AB/10/19/HH

The application is for an outbuilding to be constructed within the rear garden of The Coachmans Cottage, Arundel. The cottage itself is a Listed Building, which is located within the Arundel Conservation Area. There also a number of other listed buildings surrounding the site. The proposal therefore has the potential to affect a number of heritage assets.

Title Coachmans Cottage Kings Arms Hill, Arundel		
Drawn by MT	Scale Scale 1:50	Date Jan 2019
Drawing No. MT/CHA/PL/004

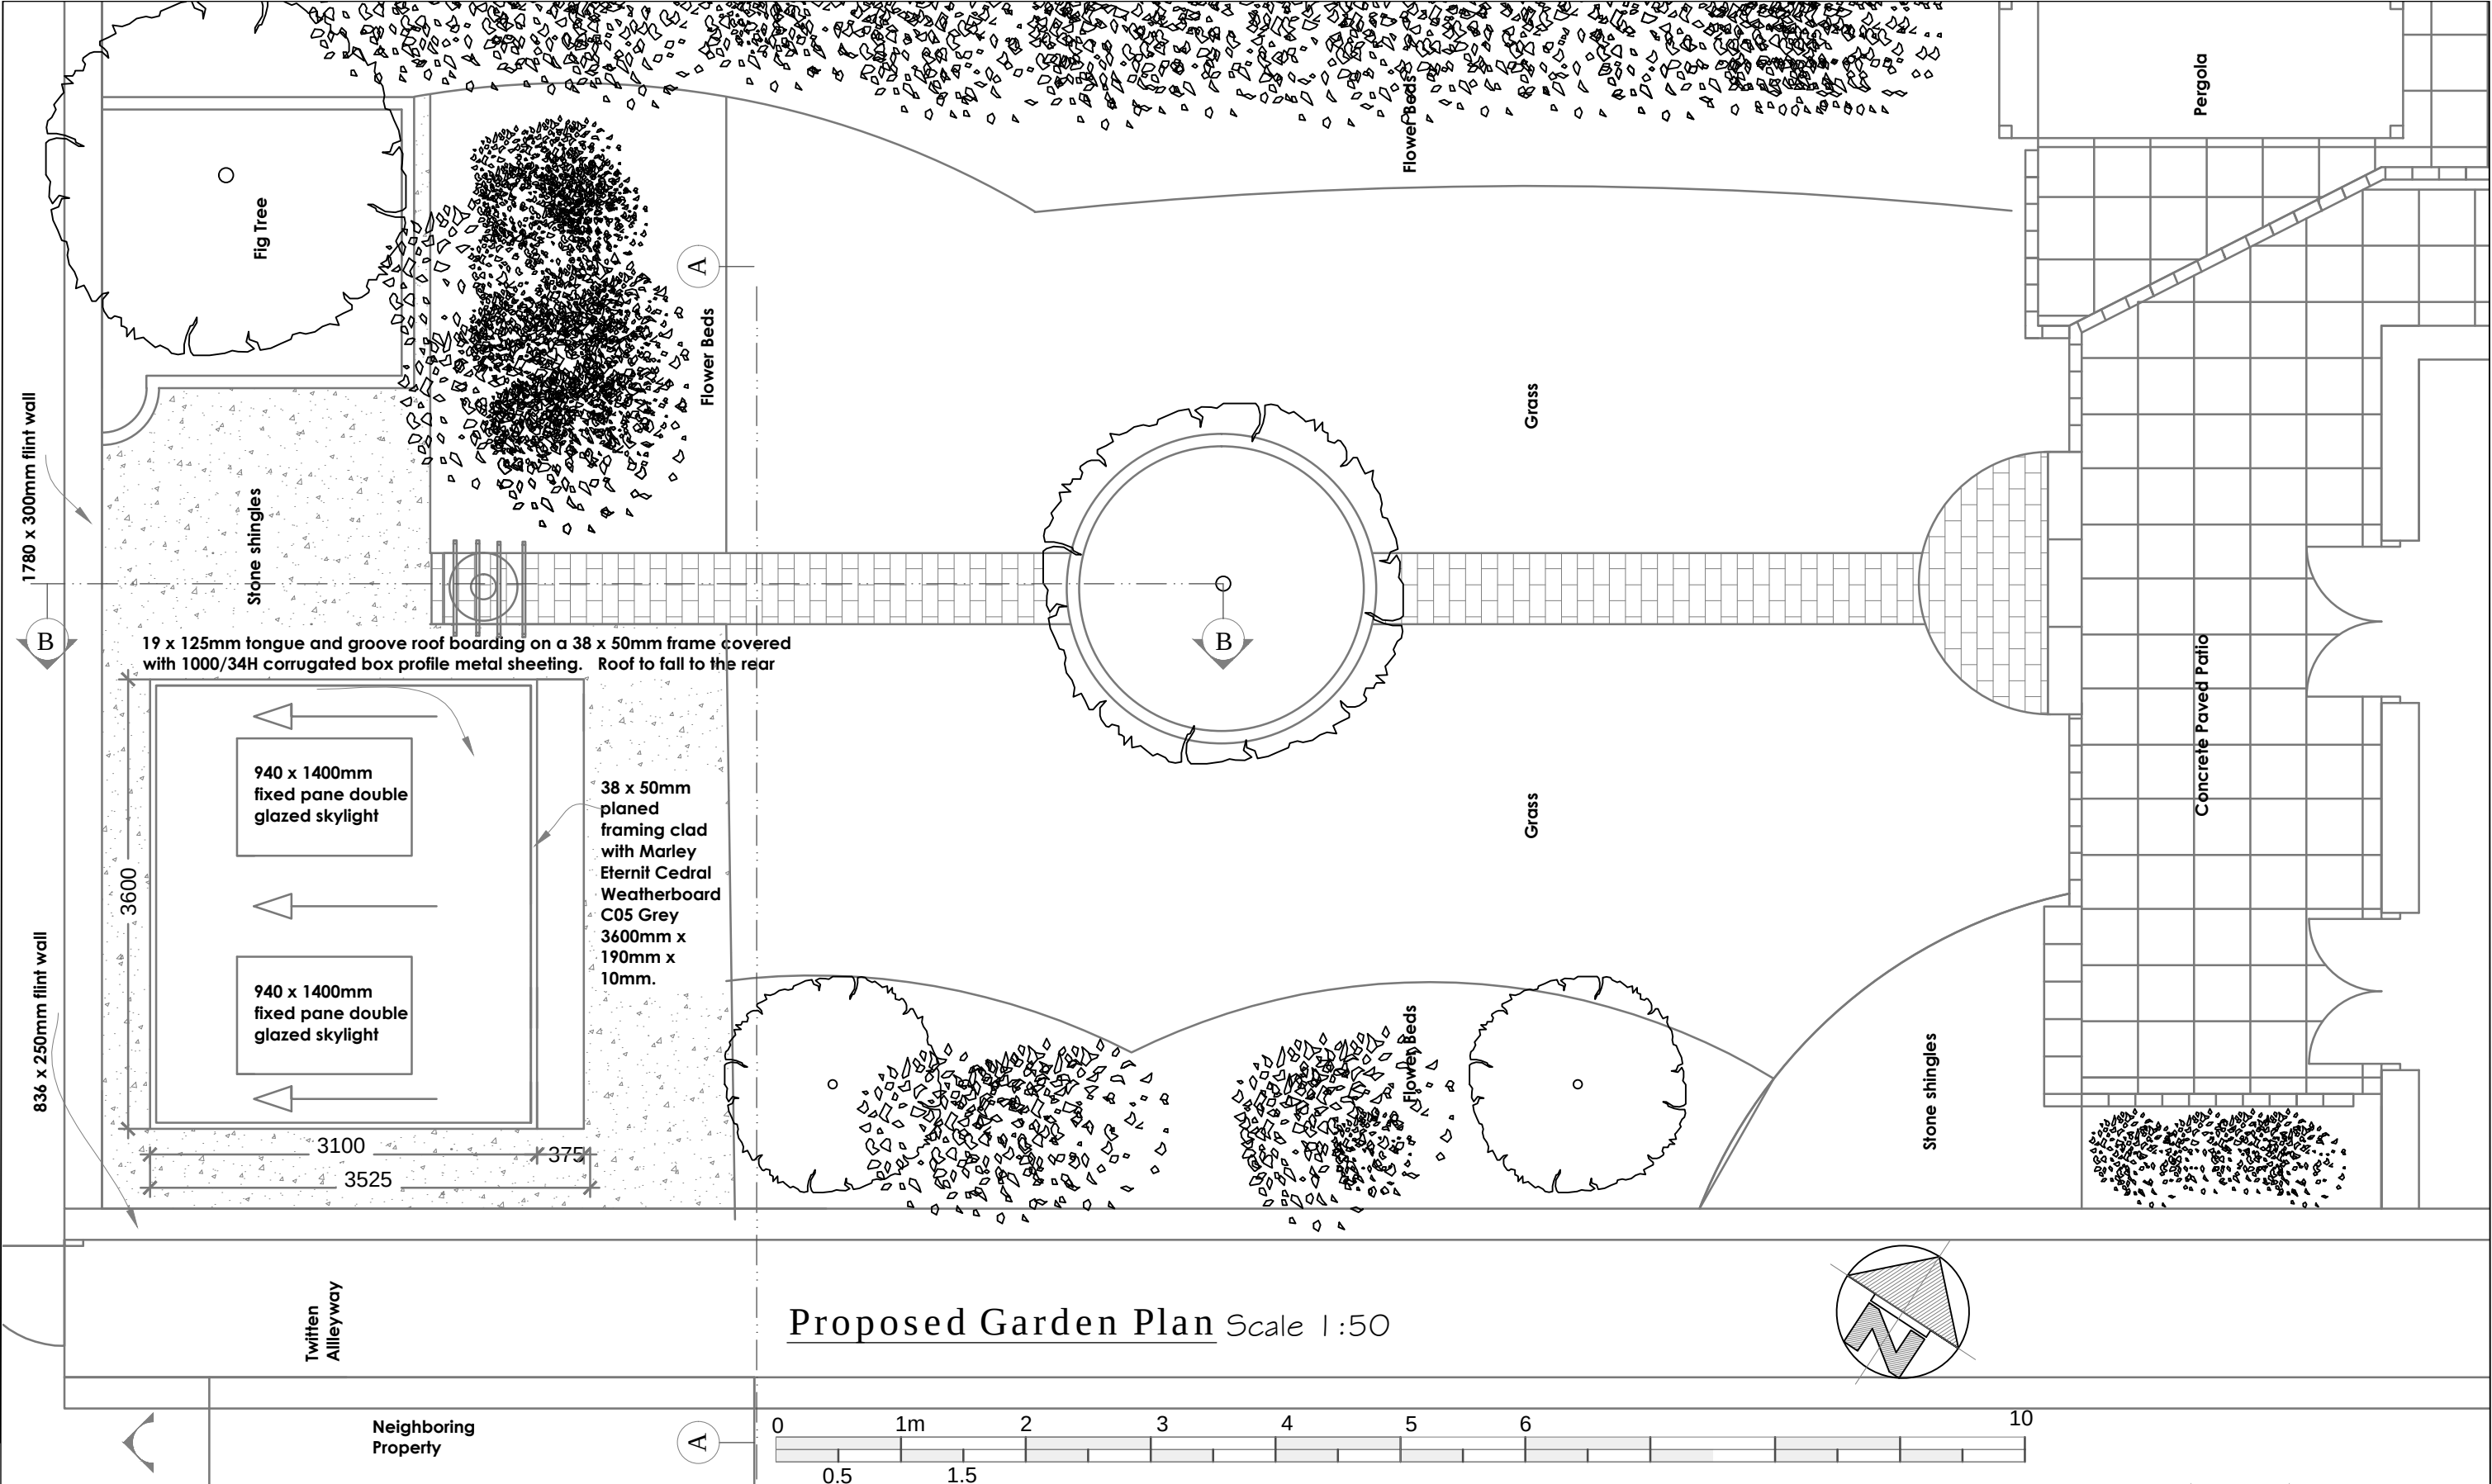
It is noted that whilst the description for the application states 'Erection of a timber constructed outbuilding within the rear garden', it is to be clad with Marley Eternit boarding. Whilst it has a wood effect, it is constructed from alternative materials. The approach within conservation areas normally is to use traditional materials to help maintain the established character. It is considered that traditional materials should be prioritised as part of any proposal.

However, it is considered that, in this instance, the materials/colours are acceptable and will not harm the conservation area, or the neighbouring Listed Buildings. The skylights should ideally be of conservation standard.
